Re: Objection to MP08_0244 MOD 1 Modification Request for Mixed Used Development at 23-37 Lindfield Avenue and 11 Havilah Lane, Lindfield

As a resident of Lindfield, I/we wish to lodge an objection against the proposed Modification of the subject development based on the following grounds:

1 HAVILAH LA ELEVATION
2001 SCALE1 : 250

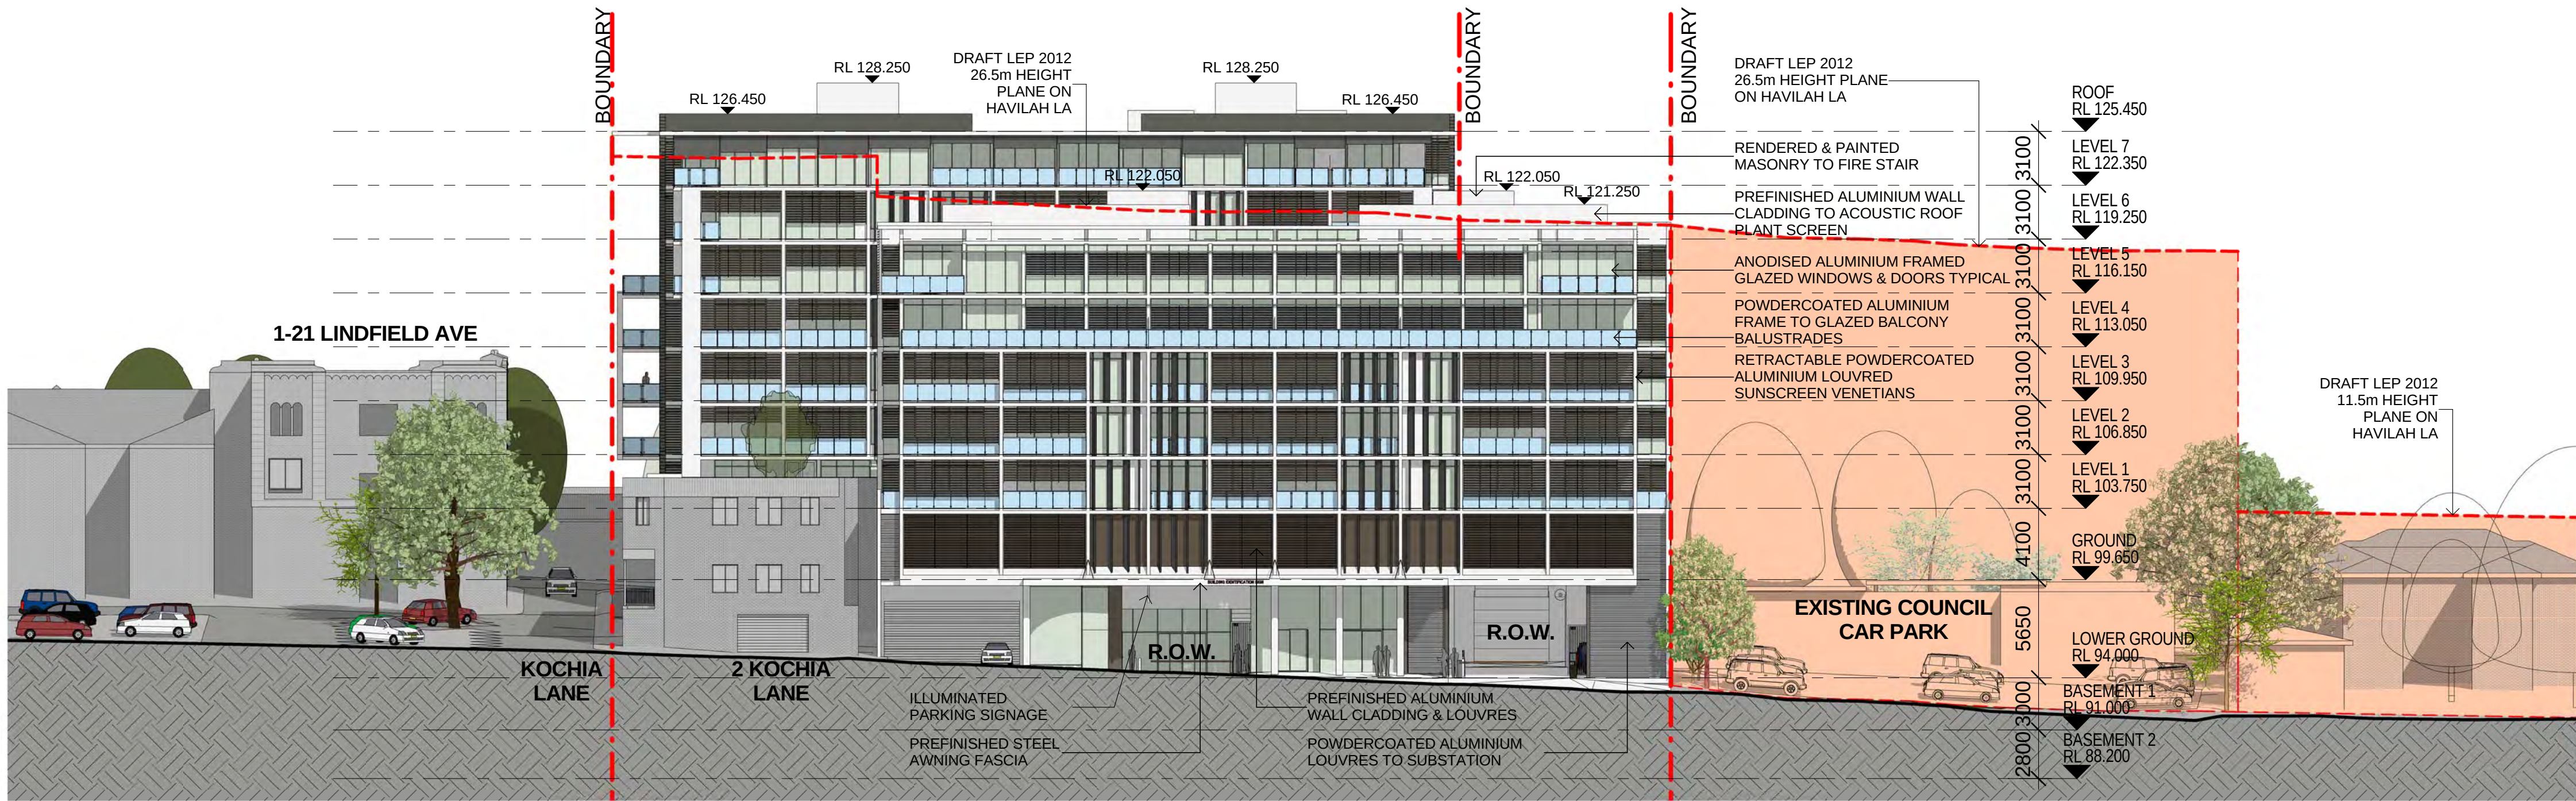
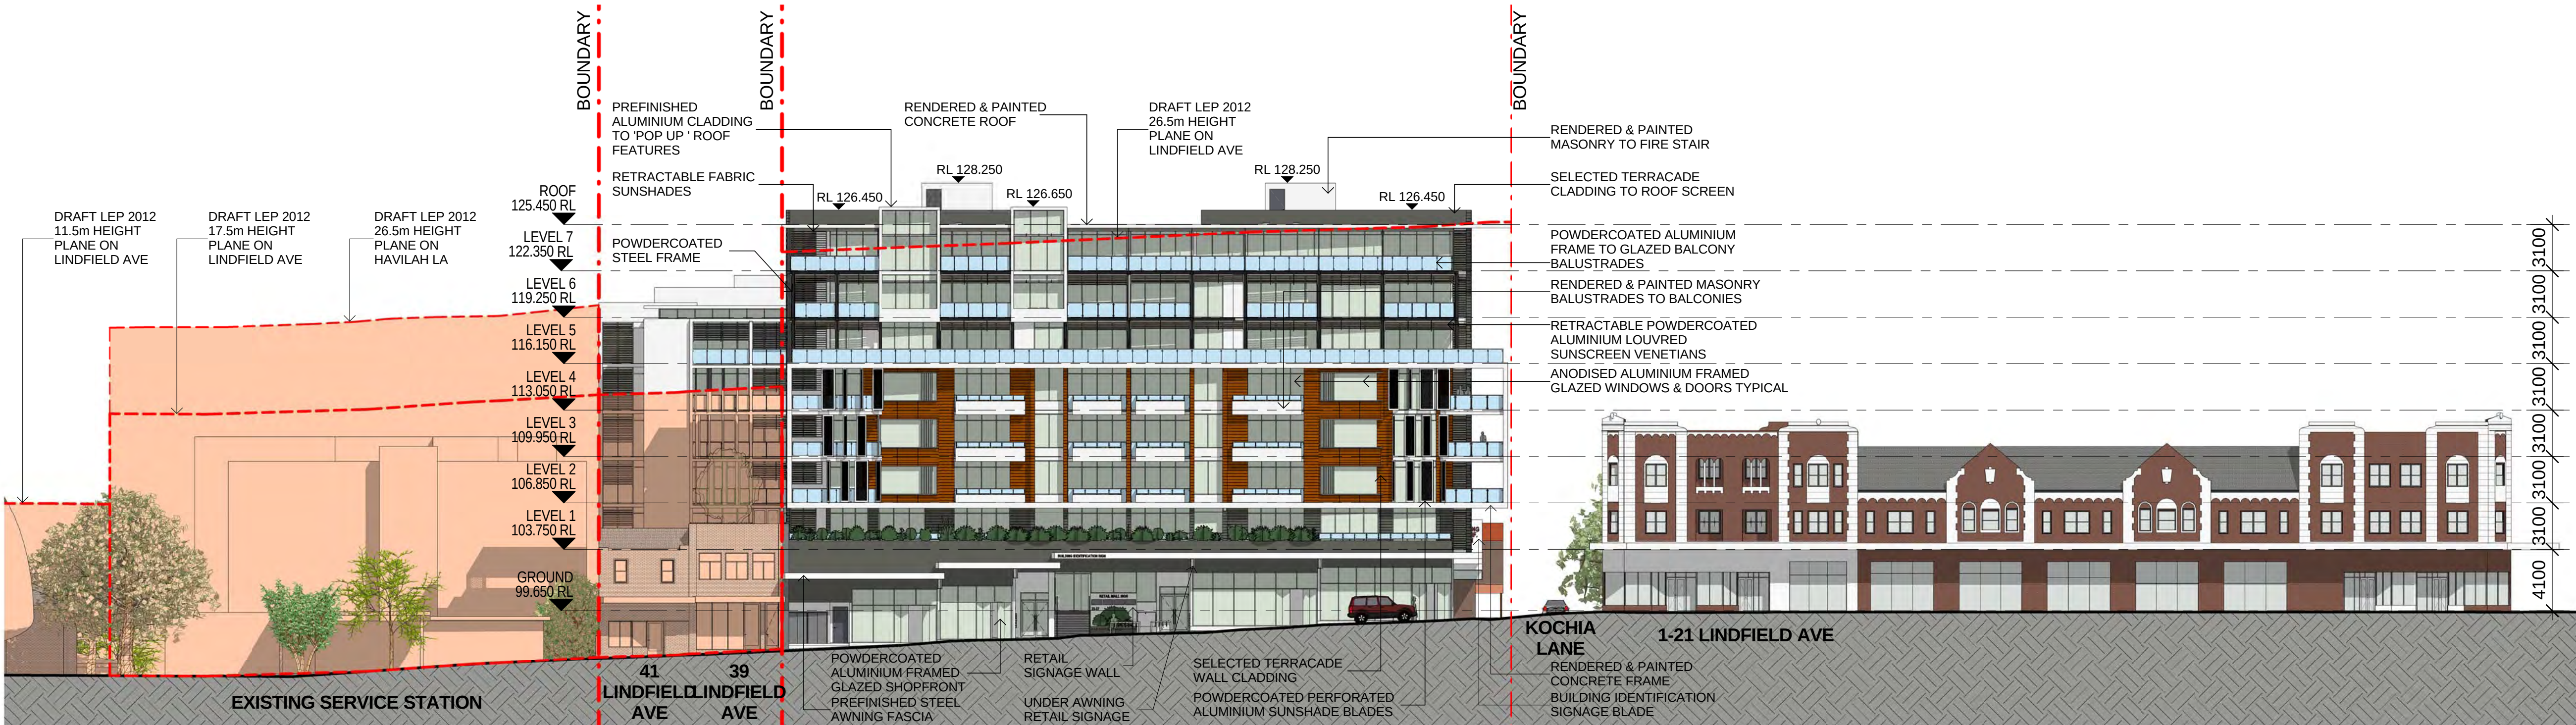
- The increase of an additional storey to both buildings: 8 storeys on Lindfield Avenue and 7 storeys on Havilah Lane creates excessive height and bulk and is out of character with the surrounding buildings, including the heritage listed adjacent building on Lindfield Avenue

- The additional storey (combined with less set back than the approved design) on Havilah Lane now creates privacy concerns for over 40 apartments in the adjacent 8 Havilah Lane, 8 Kochia Lane and 2-8 Milray Street residences
